Our ref: 270 Pacific Hwy Crows Nest BTR (SSD-79658964)

19 September 2025

Subject: Request for Additional Information

SCALE	DRAWN BY	APPROVED BY	DRAWING ELEVATION
1:300 @A3 30mm ON ORIGINAL			ELEVATION - SOUTH
		PRINT DATE 23/10/2025	PROJECT NUMBER 22501
			DRAWING NUMBER DA-11004
			ISSUE C

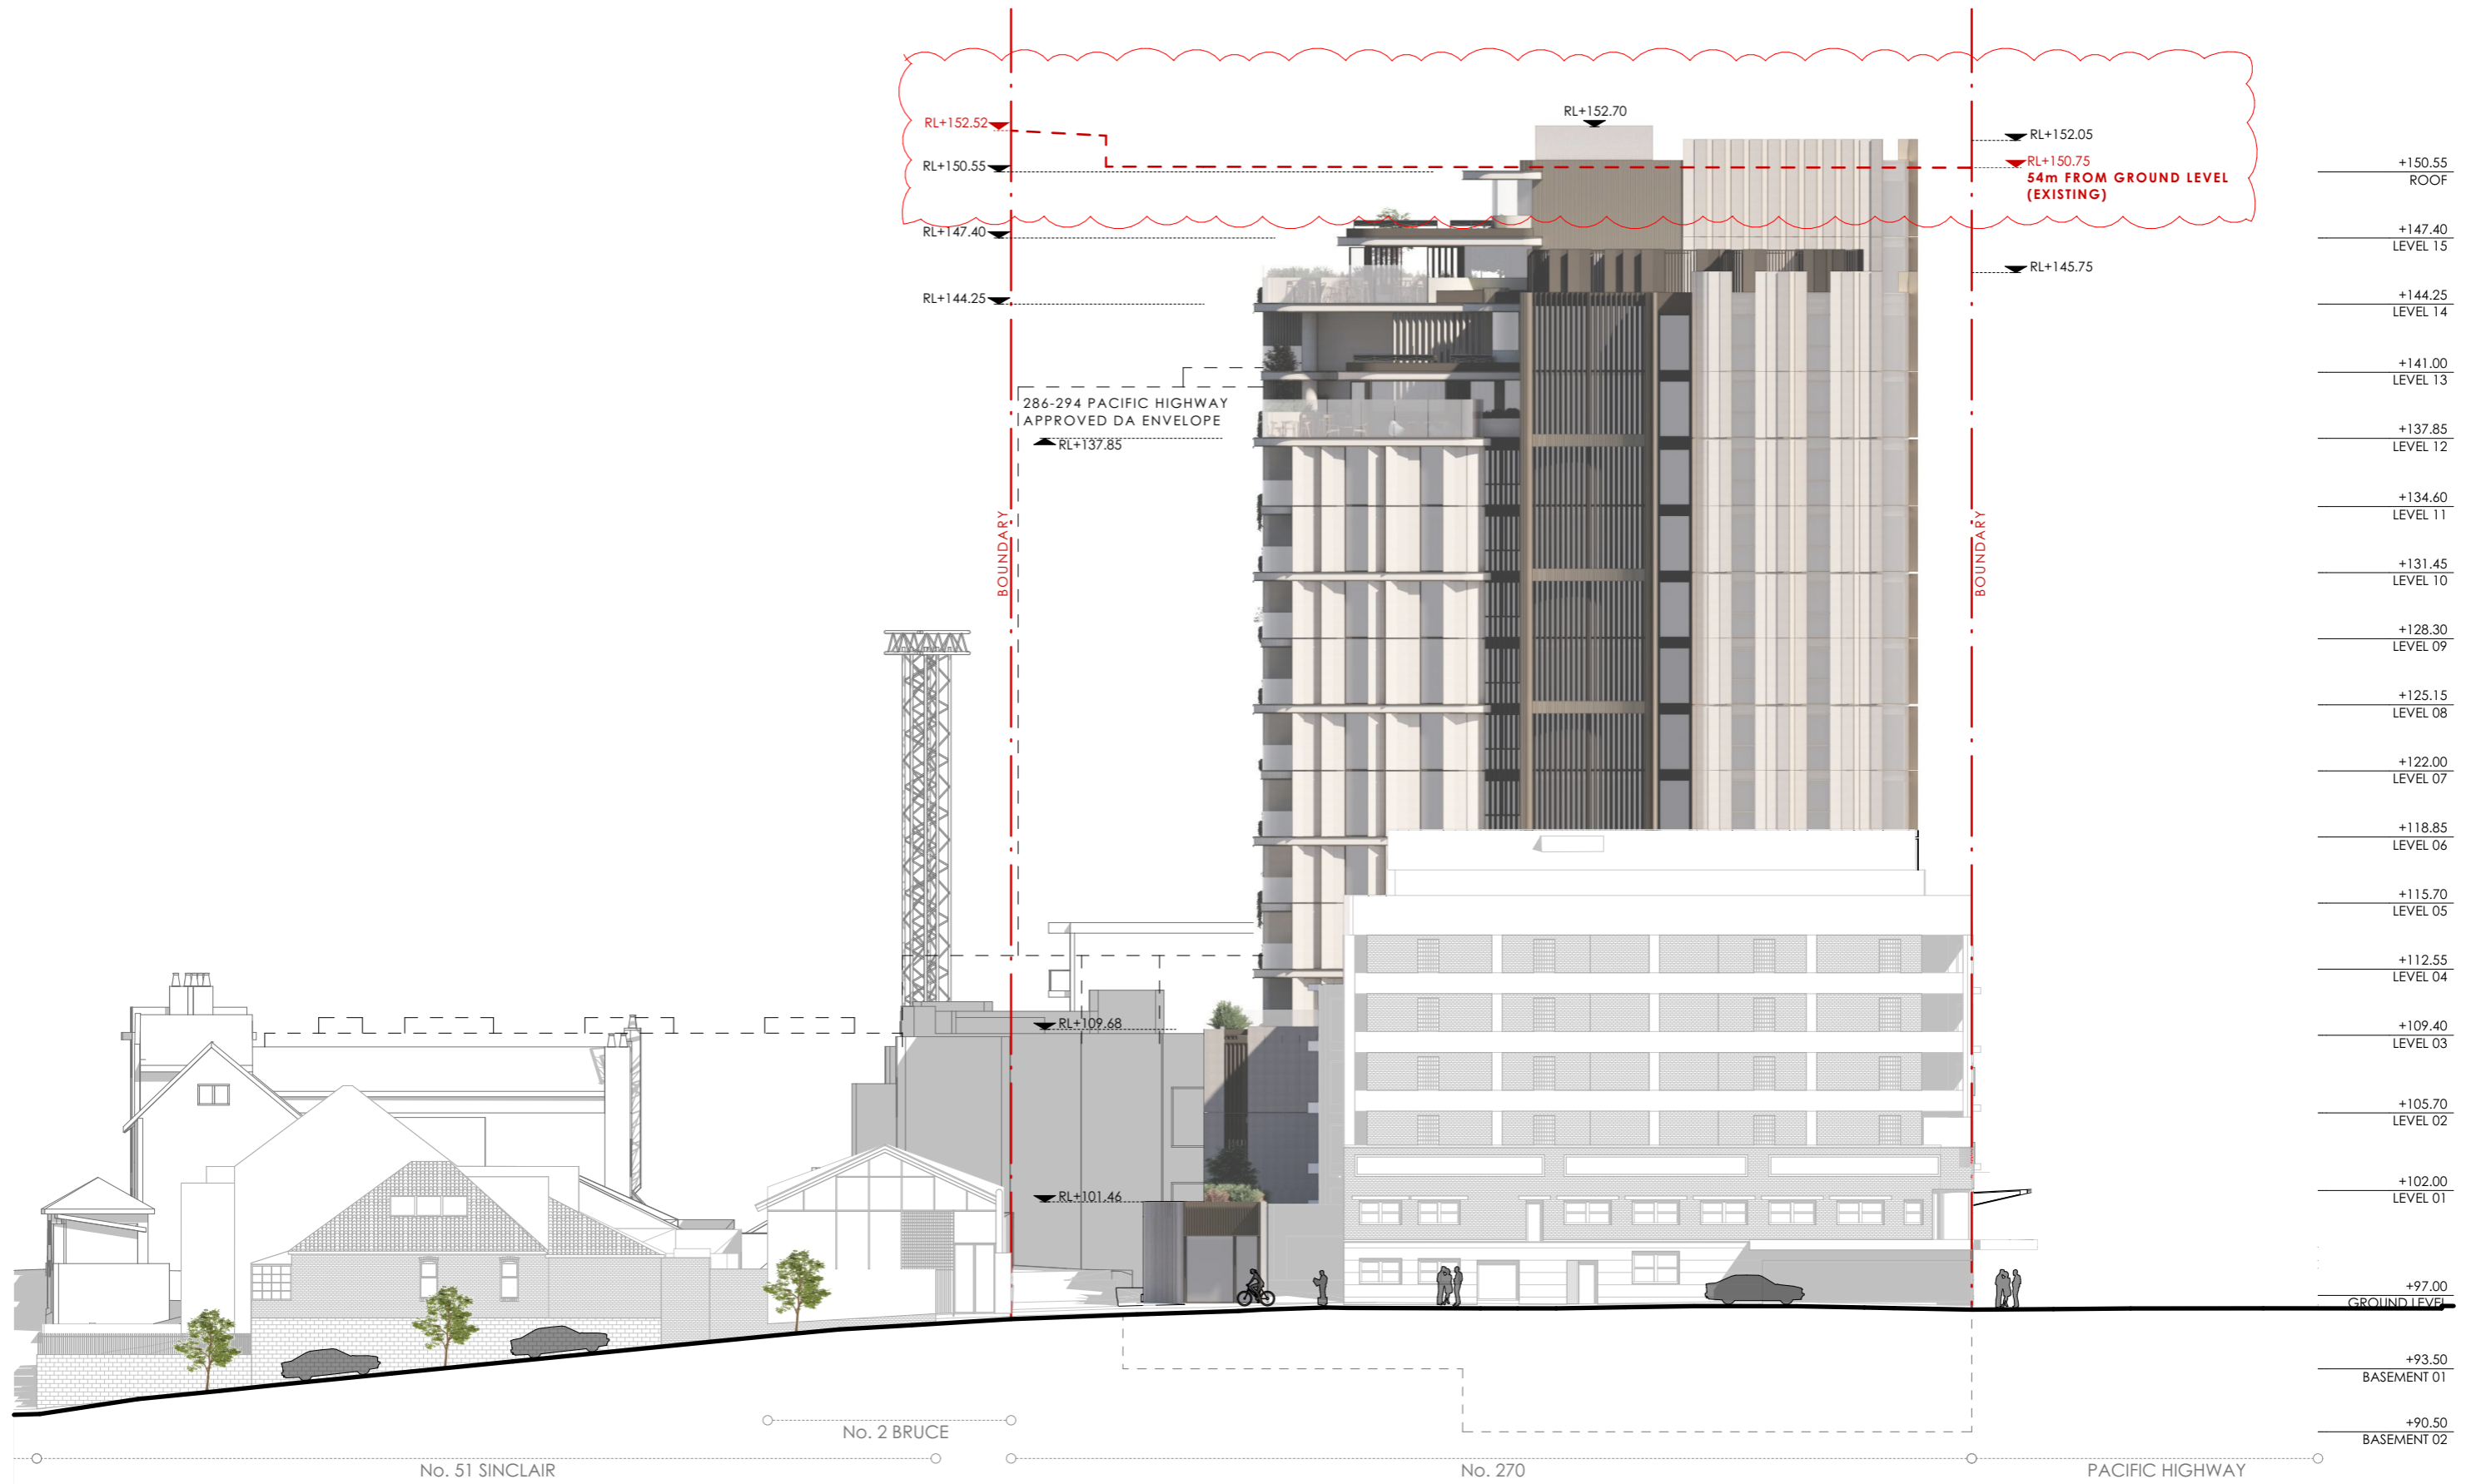
The clause 4.6 variation request for height has assessed the maximum building height using the 'Merman' method. The Department does not consider that the decision in *Merman Investments Pty Ltd v Woollahra Municipal Council* [2021] NSWLEC 1582 (Merman) sets a precedent for the meaning of 'existing ground level' and the calculation of maximum building height that the Department is required to adhere to.

The Department considers that the more appropriate way to extrapolate 'existing ground level' in this instance is to use the 'Bettar' method (*Bettar v Council of the City of Sydney* [2014] NSWLEC 1070). The Department considers that the determination of the existing ground level should relate to the overall topography of the site. This can include considering the footpath level and the rear laneway level for this site. This approach would result in a more appropriate height plane for the site consistent with the intention of the height control described in the *North Sydney Local Environmental Plan 2013*.

This method of determining ground level (existing) has been affirmed in several other recent cases. It is requested that the clause 4.6 variation request is updated to reflect this application of determining ground level (existing).

The Department considers that the current amenity outcome achieved for these units can be improved. The Department recommends that the design is amended to include operable windows on all units, at a minimum, to achieve an acceptable level of amenity for all units, being a minimum of 60% of units receiving natural cross ventilation.
